Recommendation Report

EP/111/12

Description: Demolish 1 house (60 Sea Lane); partially demolish 1 house (45 The Ridings); construct 3 detached houses; alterations and extensions (45 The Ridings)

**Re: Planning application – 45 and 47 The Ridings and 60 and 62 Sea Lane,
 East Preston, Littlehampton, BN16 2TW**

8217 / 101

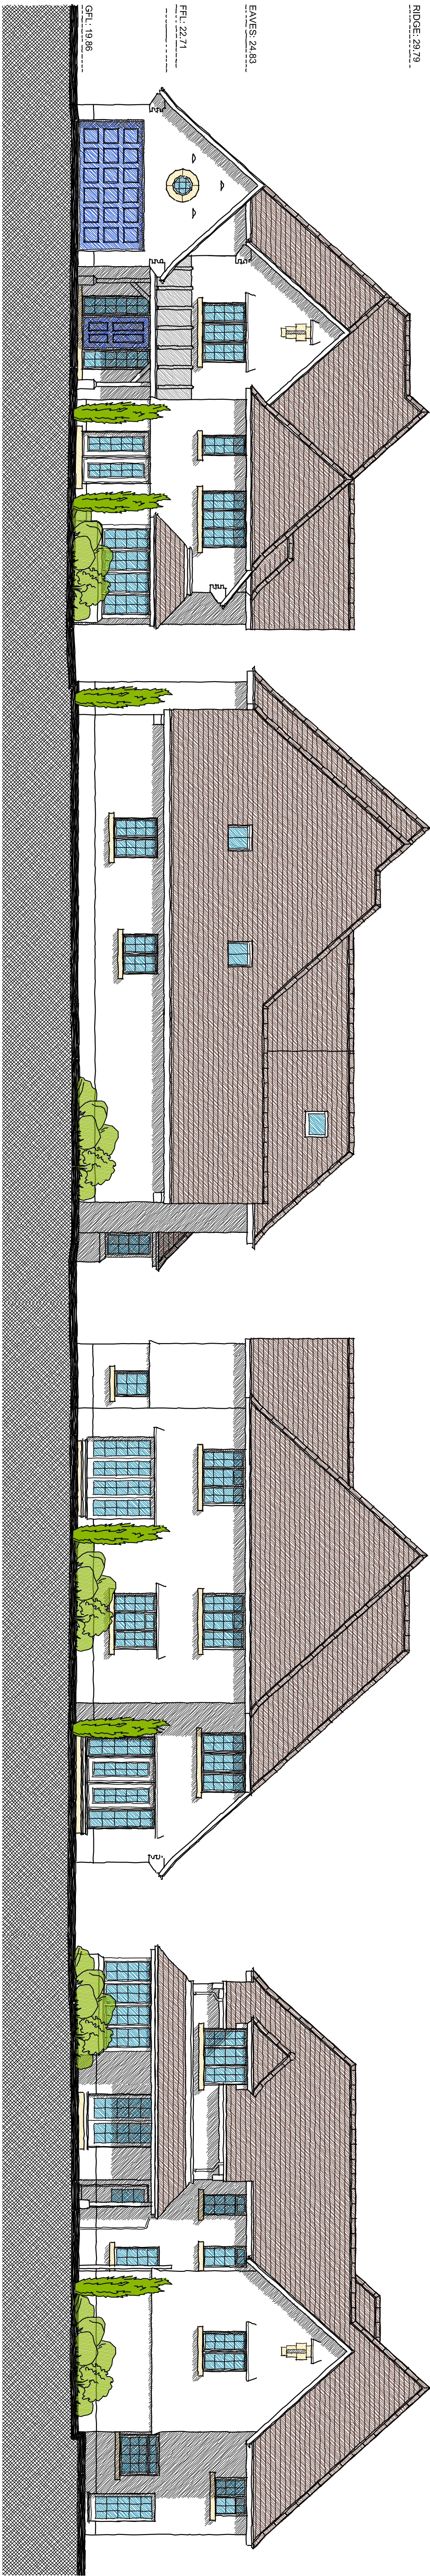
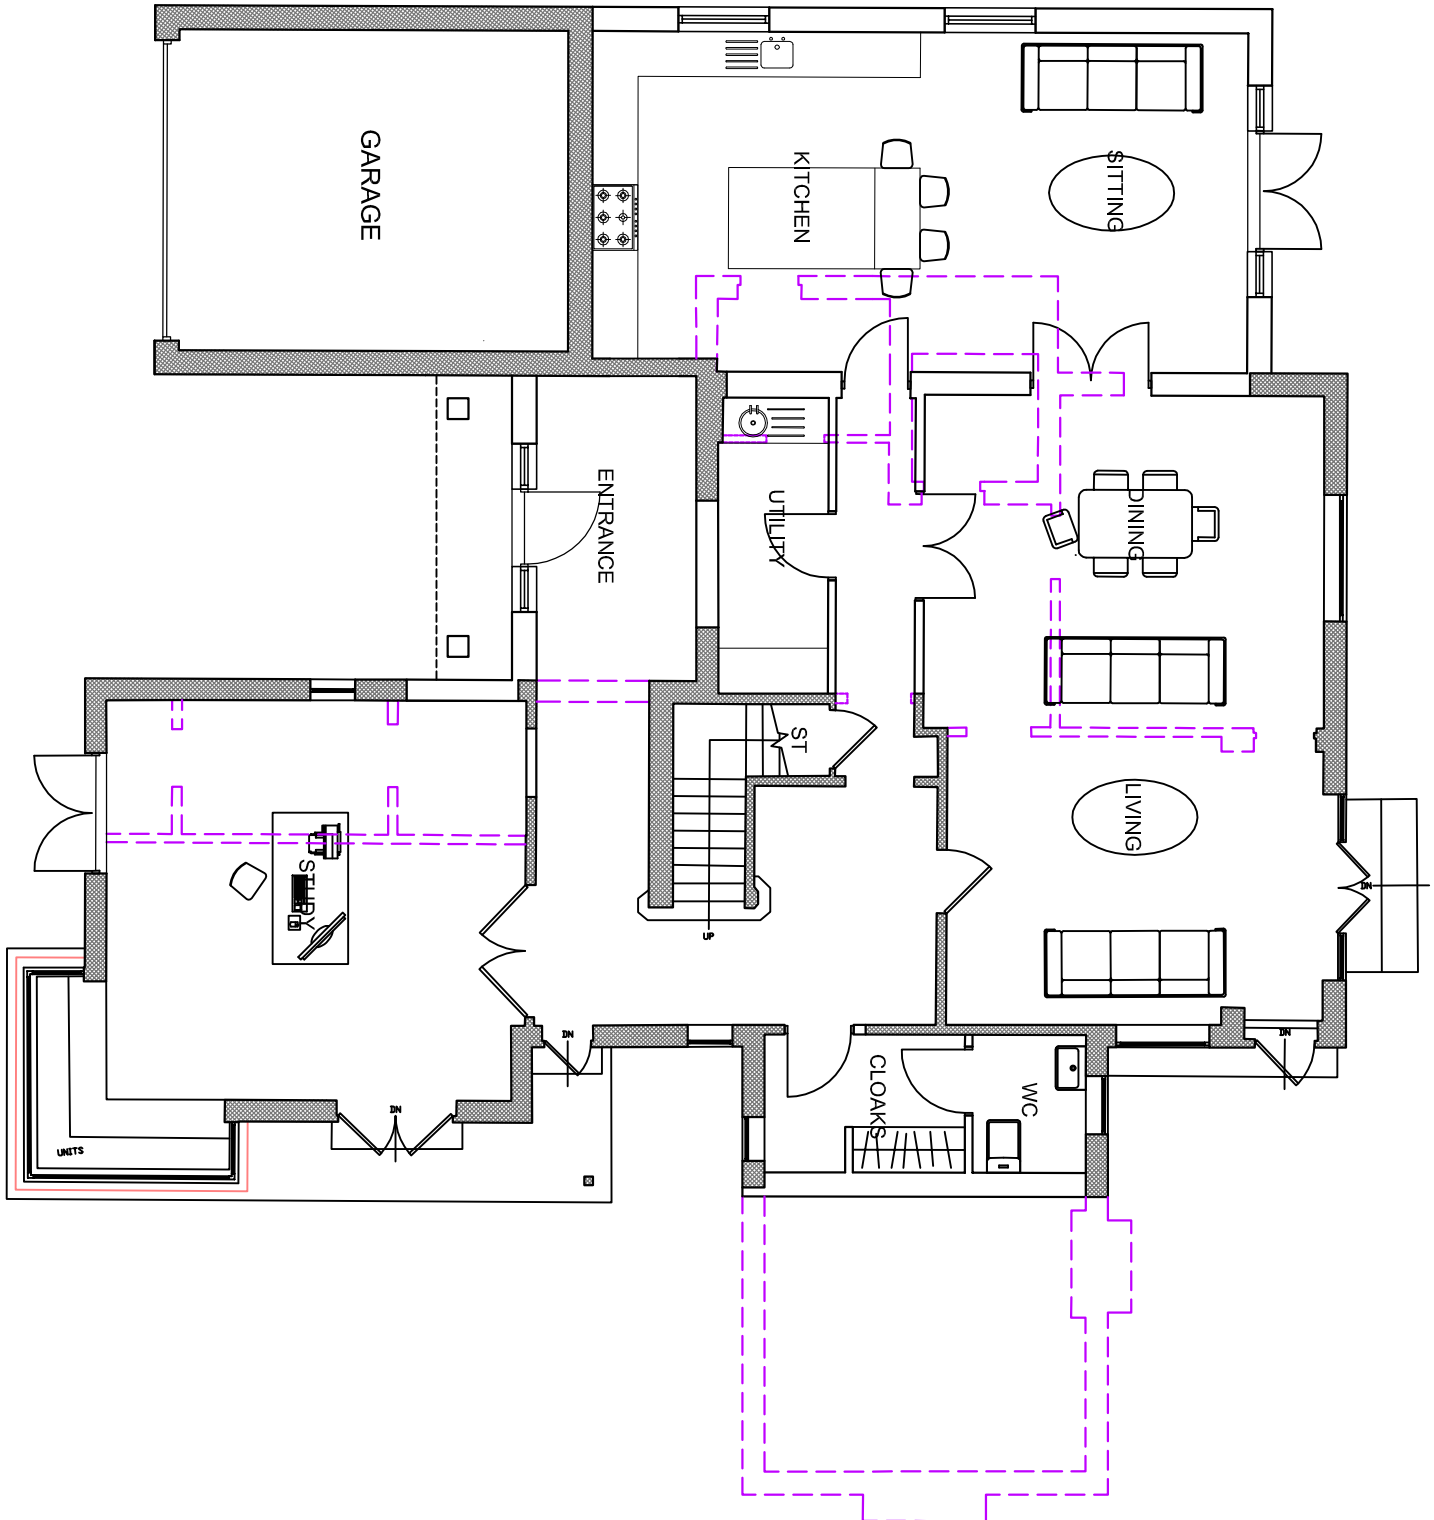
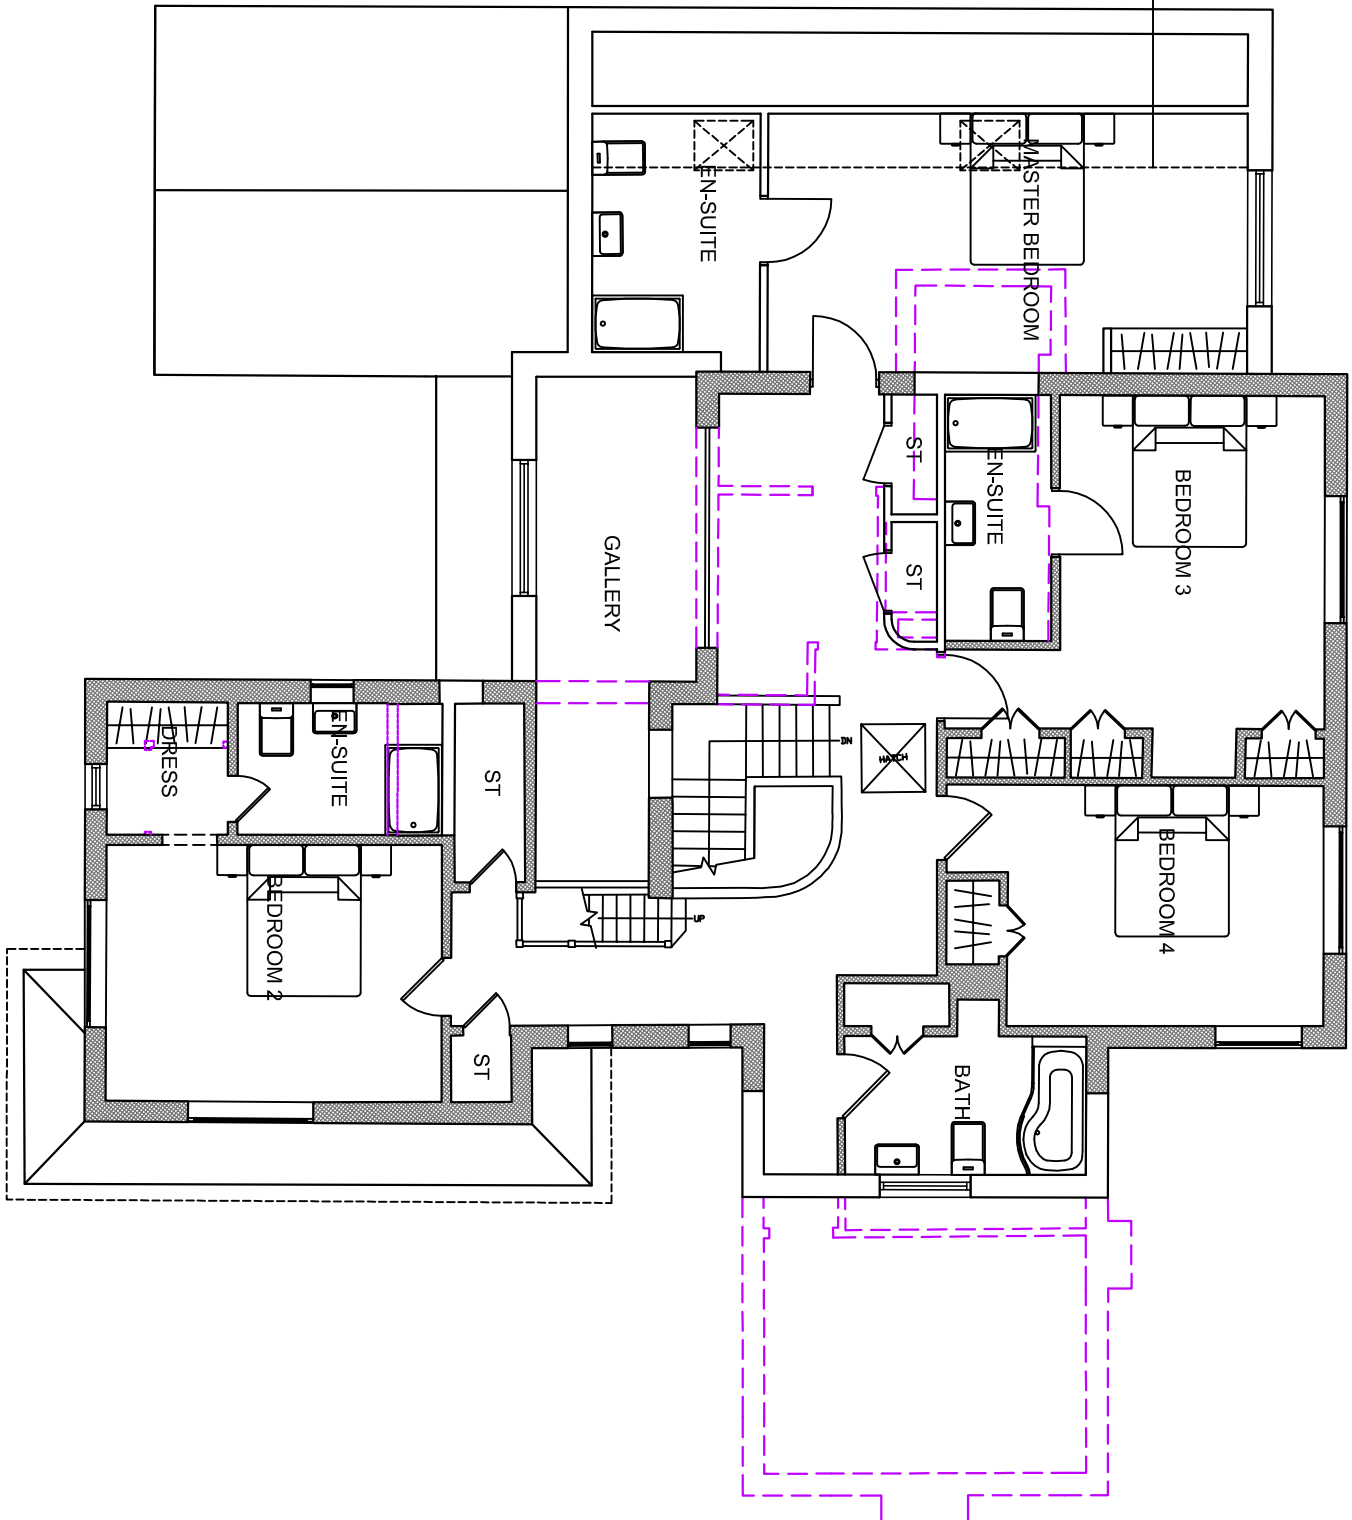
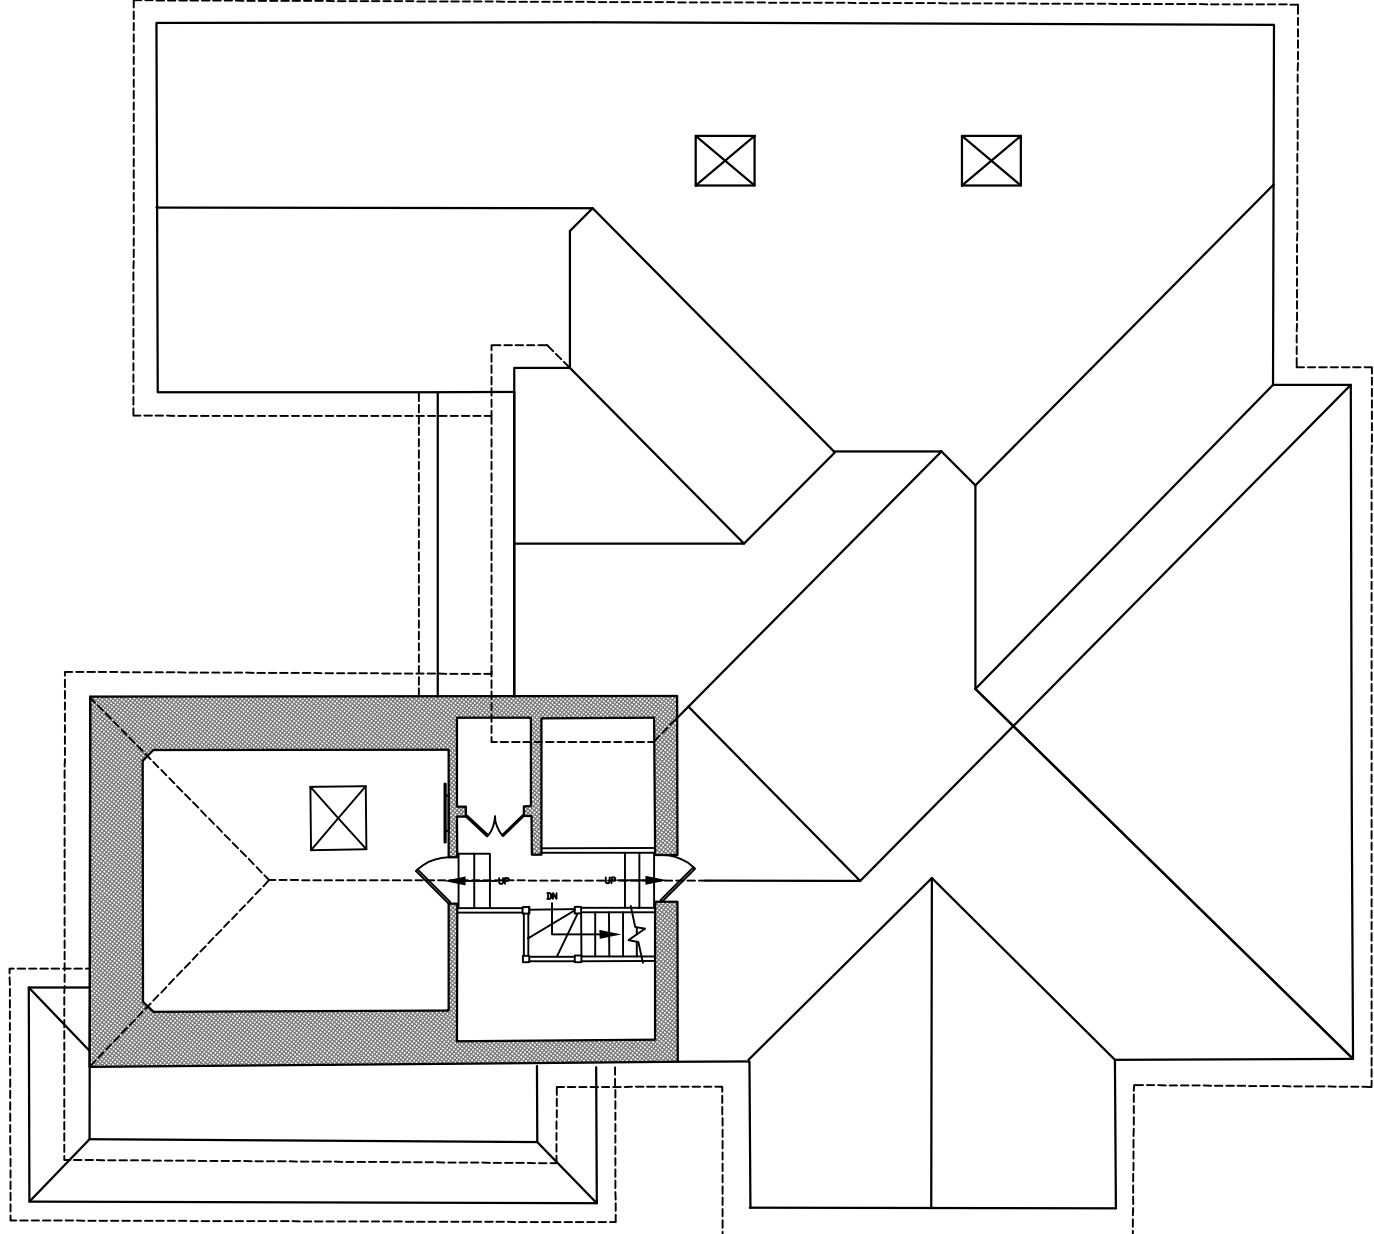
Without prejudice, I consider that reducing the overall ridge height would be beneficial to the appearance of the proposal and such an amendment can be accepted without generating a requirement for re-advertising. I have also noted that the submitted plans contain the note 'Do Not Scale' and I would request that this is amended to refer to 'except for planning purposes'.

I would also appreciate clarification of the basis for the GFL, FFL, eaves and ridge heights given on the submitted plans.

Plans ref. 101A and 102A show revised roof arrangements for the existing property at 45 The Ridings and the proposed dwelling at 47 The Ridings. The ridge of 45 The Ridings will, as a result of the proposal, now be lower than it currently is. I trust that the concerns of neighbours in relation to height and massing will thus be overcome.

scale AS SHOWN @ A1	checked GR
date AUGUST 2012	drawn WD
8217 / 100

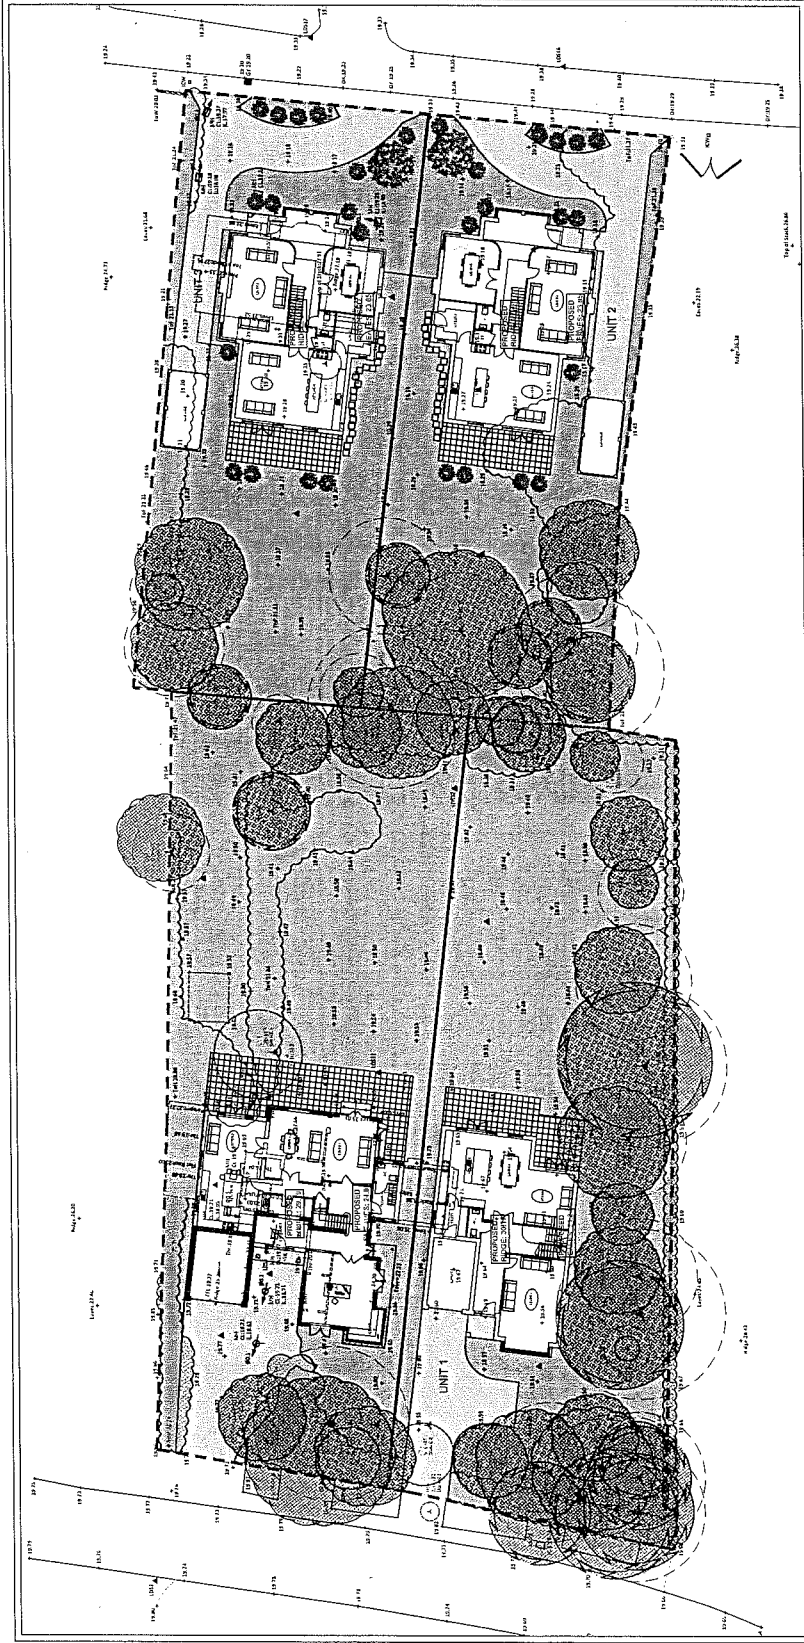
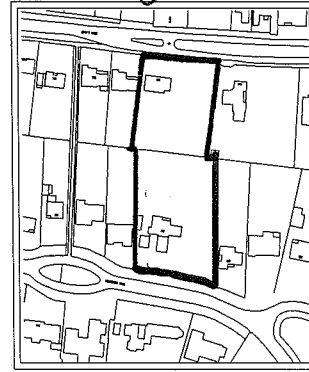
I can confirm that the above application is on the agenda for 03-07-2013 Committee. However, I have today received the comments of County Highways whose comments can be viewed on line. It is noted that visibility is improved for unit 2 on Sea Lane, but this has resulted in loss of the required turning area to enable vehicles to enter and leave the site in forward gear. Therefore a further modified plan is required to be submitted for consideration which should include a swept path analysis diagram.

I have received County Highways comments in respect of the above application which are available to view on the Council's web site. Without prejudice I would appreciate receipt of additional plans detailing visibility splays within 10 days of the date of this e-mail.

Plan ref. 100 Rev B also shows the visibility splay requested by WSCC Highways and an associated revision to the access arrangement to the new house at 62 Sea Lane. The plan also shows a new section of hedging on the northern boundary, adjacent to 43 The Ridings, following discussions with and to address the concerns of the resident of that property.
